RE: Attached letter from Kirklees Council regarding application number 2024/91008 at location adj, 115, Westfield Lane, Wyke, BD12 9LY

Bridges & Structures Manager
Structures Section

NOTES

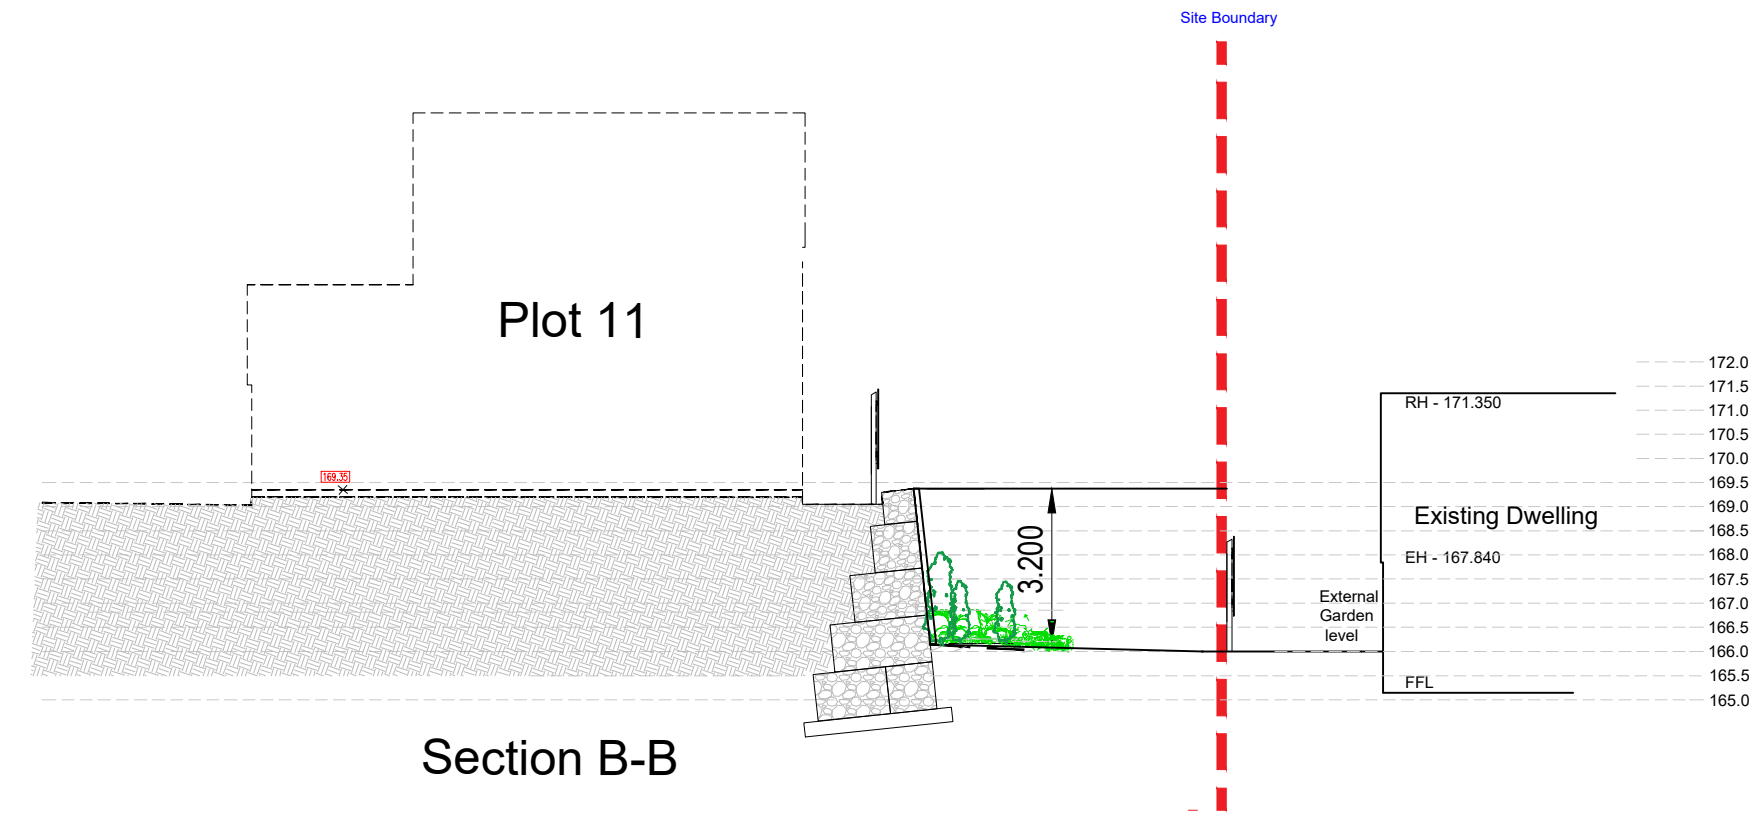
- 1) Before the development commences, the design of proposed retaining walls adjacent to the existing/ adoptable highway including footpath (Ref SPE/31/10) shall be submitted (via the submission of AIPs) and approved by the Highway Authority in writing. The approved scheme shall be implemented prior to the commencement of the proposed development and thereafter retained during the life of the development.

Client	YORKSHIRE CHOICE HOMES
Project	WESTFIELD LANE, WYKE
Title	LONGITUDINAL SECTIONS

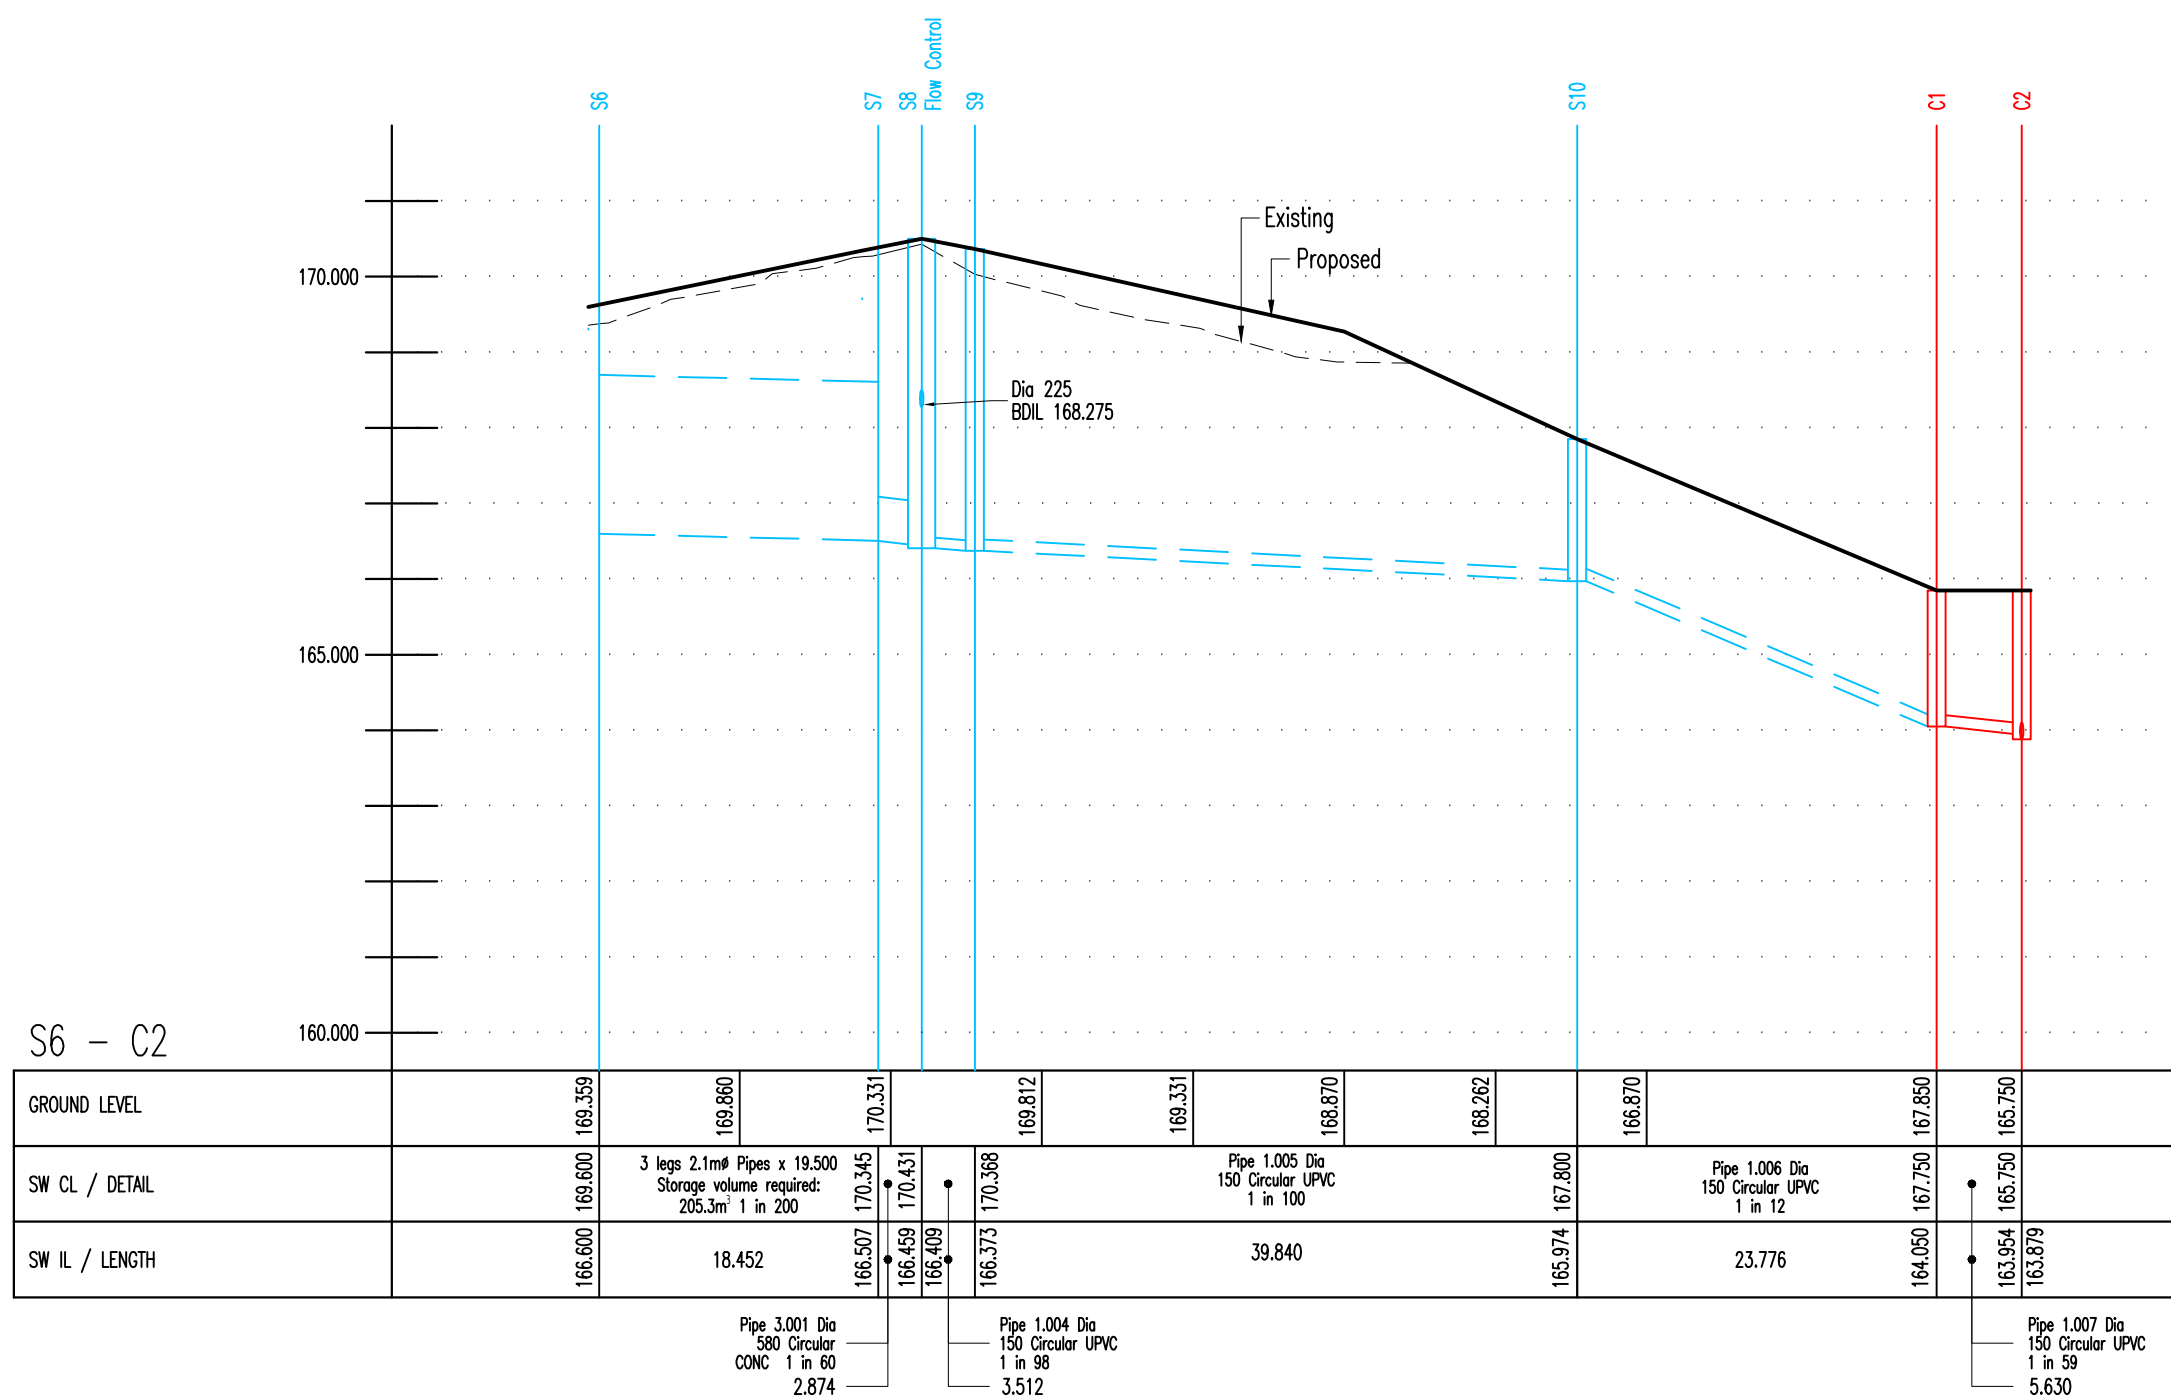
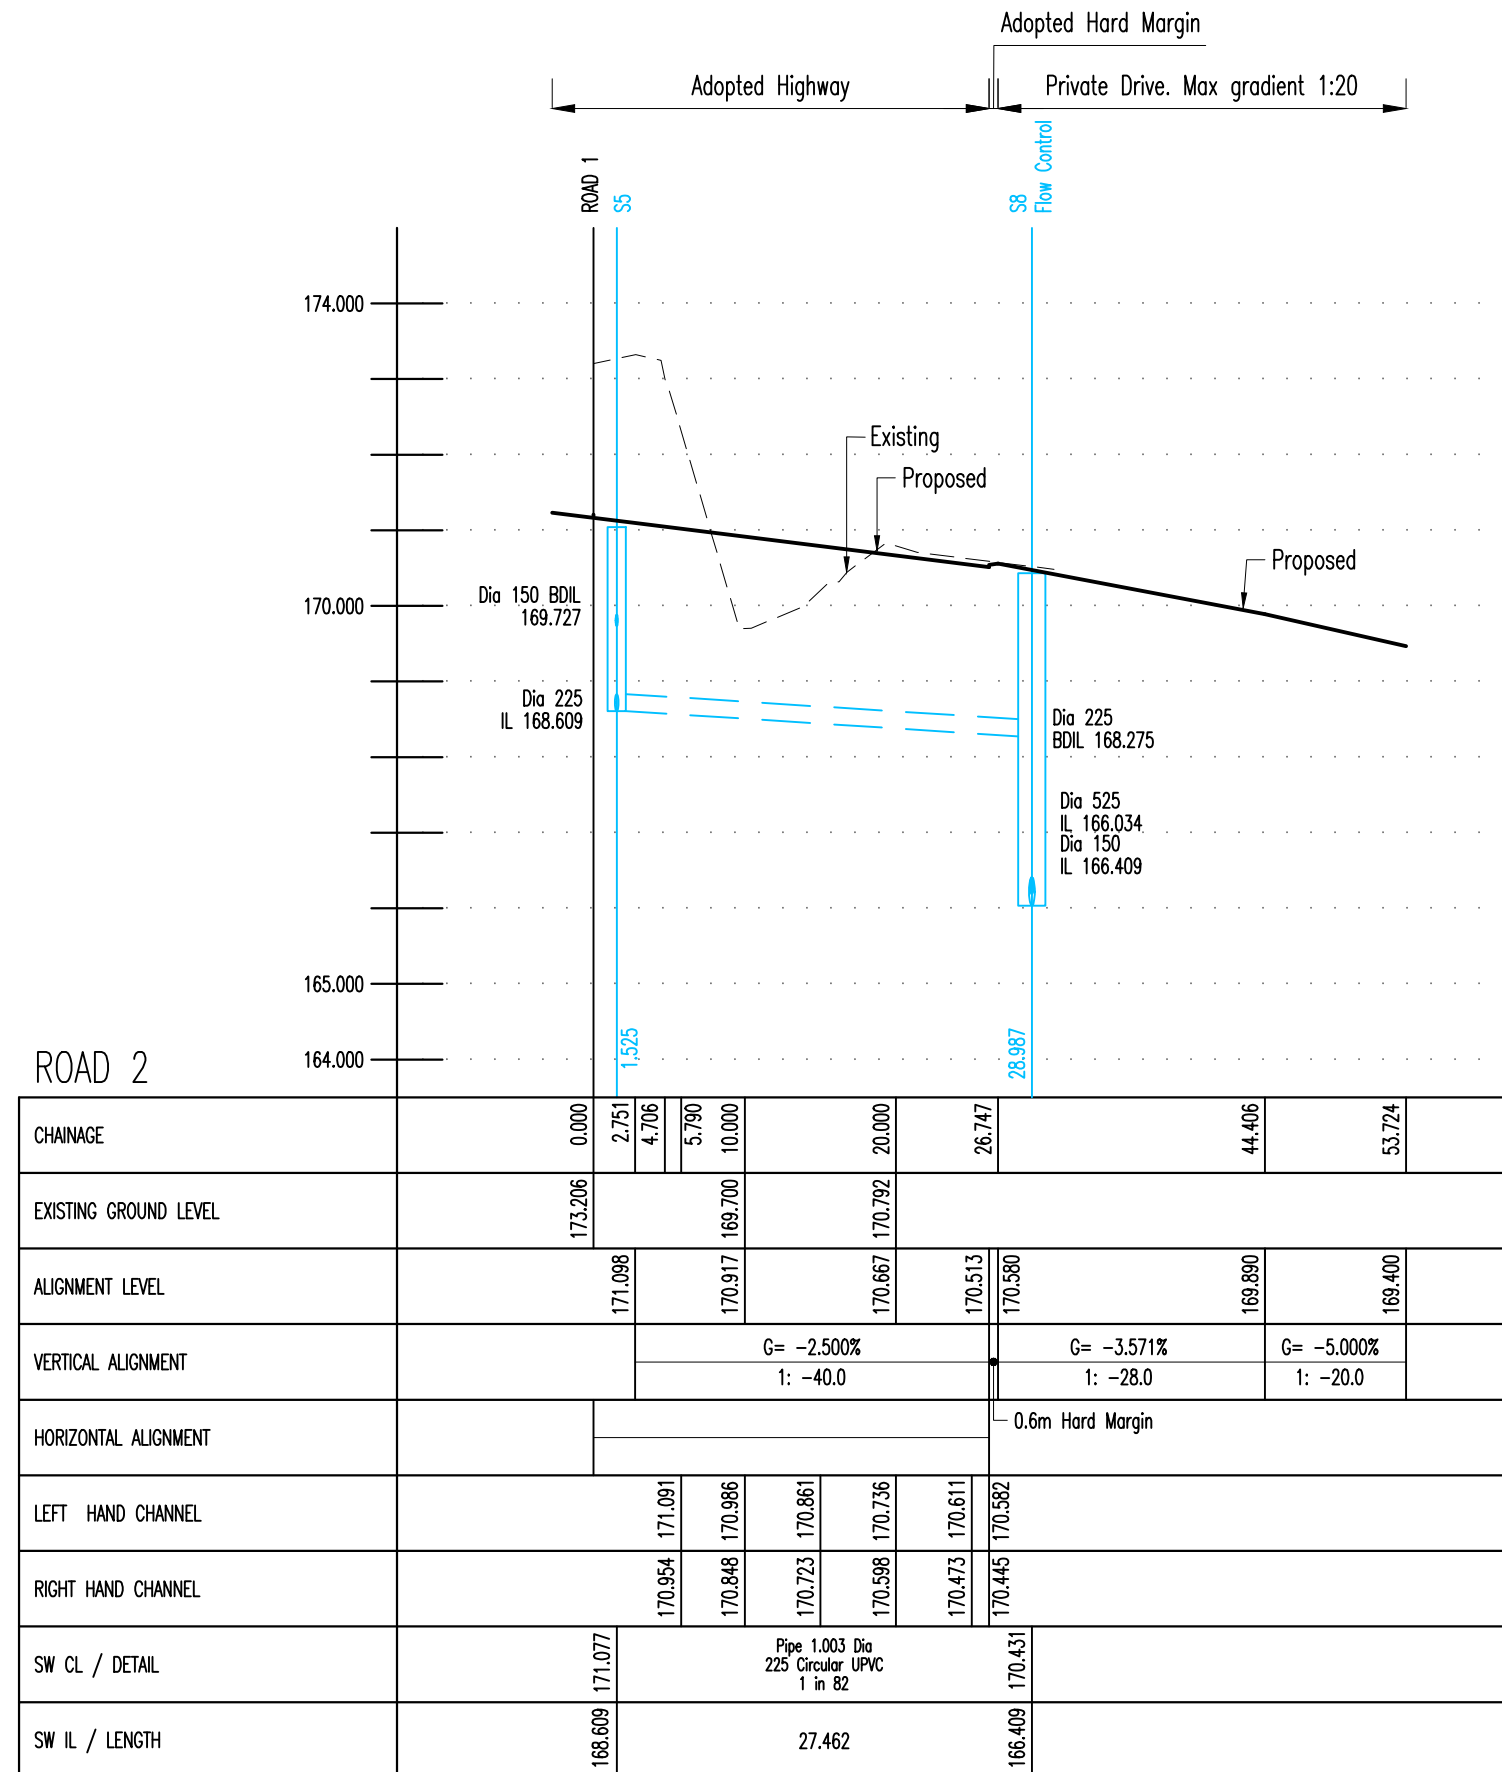
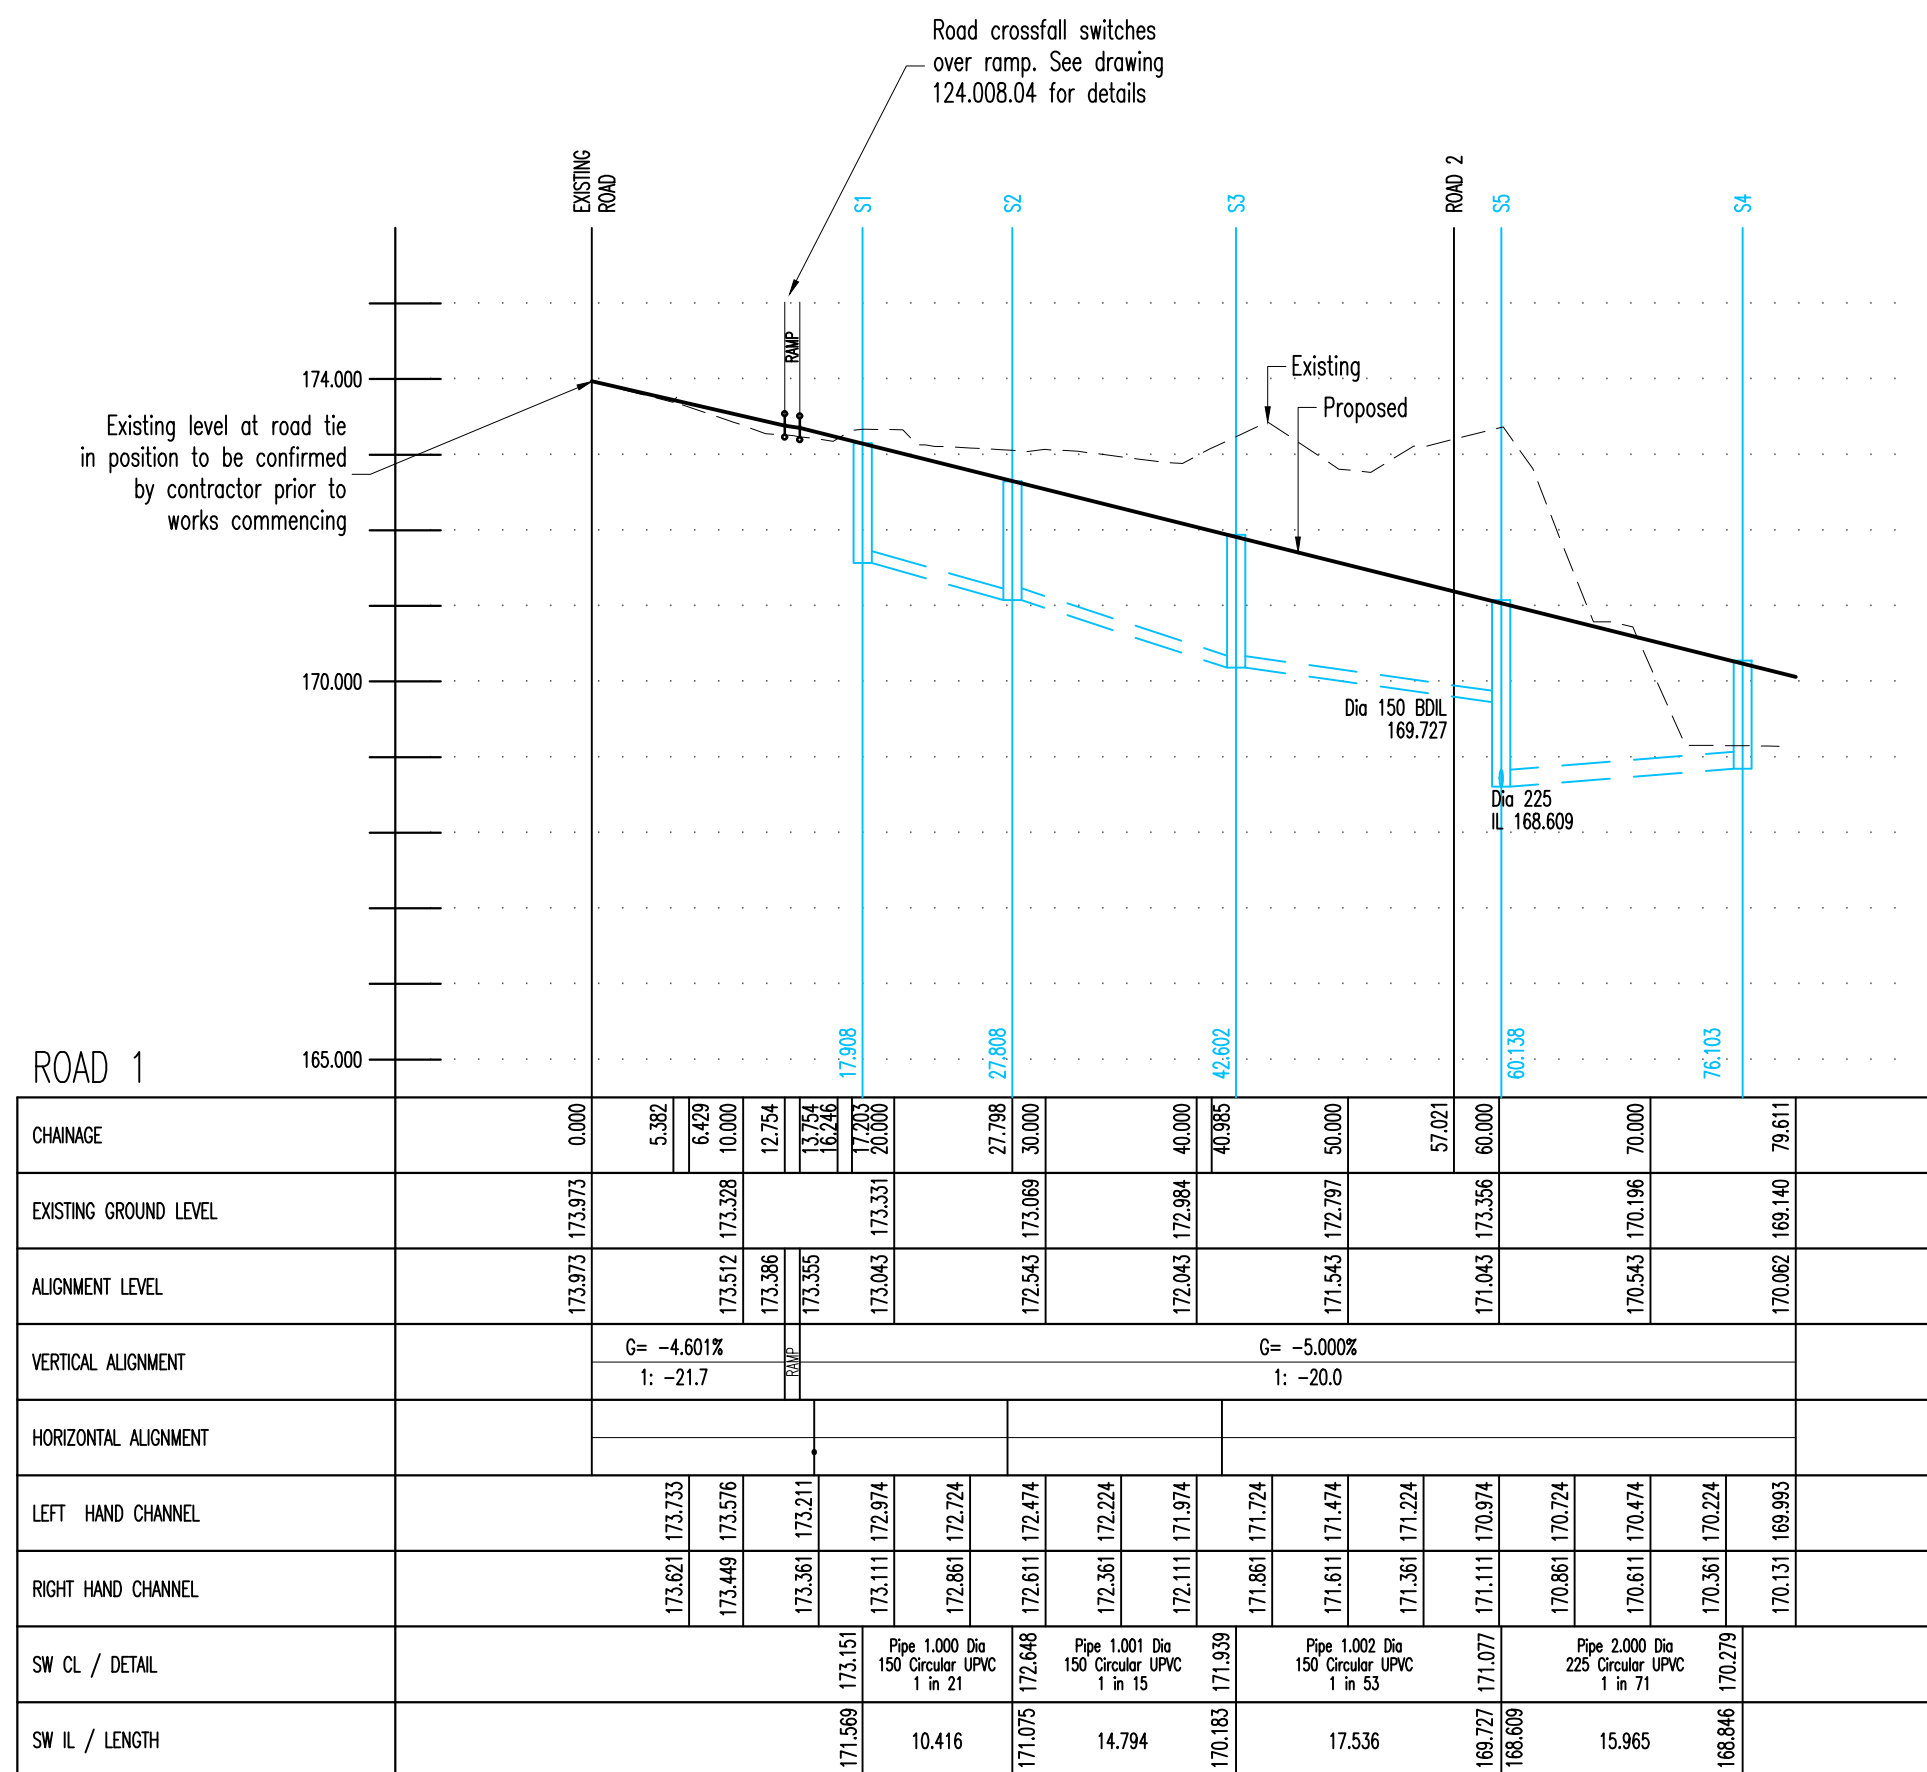
- 2) Before the development commences a scheme detailing the location and cross-sectional information together with the proposed design and construction details for all new surface water attenuation tanks/pipes/manholes located within the proposed highway footprint or influence zone of highway loading shall be submitted to and approved by the Highway Authority in writing. The approved scheme shall be implemented prior to the commencement of the proposed development and thereafter retained during the life of the development. See <https://www.kirklees.gov.uk/beta/regeneration-and-development/pdf/highways-structural-procedures.pdf> for further details and in particular, for the certification of oversize pcc manholes and their cover slabs, as advised in this document.

All new storm water attenuation tanks/pipes/culverts with internal diameter/ spans exceeding 0.9m must be located off the adoptable highway. Any decision to locate these facilities within the adoptable highway footprint must be accompanied with a full risk evaluation report with particular reference to their proposed inspection, structural assessment and maintenance regime in compliance with the CDM Regulations 2015 requirements.

The adopting authority (i.e. Yorkshire Water) will also be required to produce and submit a legally binding agreement to the Highway Authority explicitly stating that they will be fulfilling their obligations in relation to the systematic and cyclical inspection and structural assessment of any attenuation structure located within the highway footprint, in full compliance with CS450- Inspection of Highway structures.

Furthermore, all new precast pipes/ culverts/storage tanks proposed for use within the footprint of an adoptable highway must comply with the Specification for Highway Works (SHW-Series 500 or 2500) and must be accredited with a BBA (The British Board of Agrément Roads and Bridges) or HAPAS (Highway Authority Product Approval Scheme) or equivalent certificate.
